**From:**  
**Sent:** 07 January 2021 10:02  
**To:** Development Control  
**Cc:**  
**Subject:** Discharge of conditions : Reference 21/00009/CONDET. F.A.O Brian Savage

Hello Mr Savage , I submitted a few drawings along with the application to discharge of conditions 21/00009/CONDET.

FRONT ELEVATION

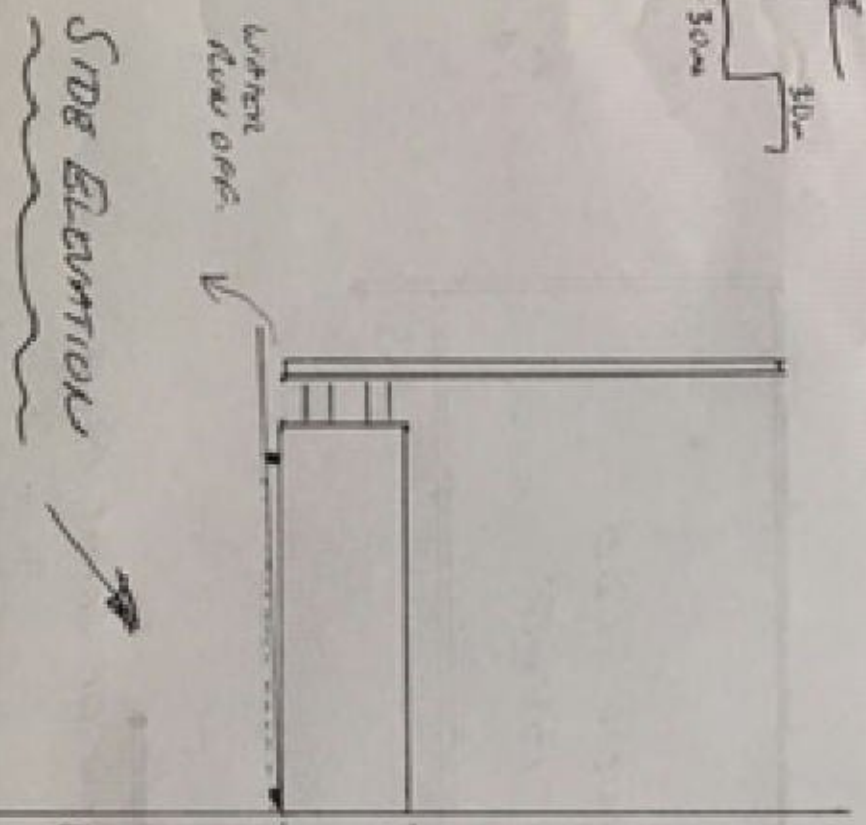
It has come to my attention that the drawing we have of the doors and windows has a mistake on the drawing sent by the supplier . It shows that the folding doors have a central column which reduces the central door leafs measurements . This is not the case and all the door leafs are of equal measure with no central post . Could this be added as a note to the application please and the design concept to be taken from the drawing . Thank you .
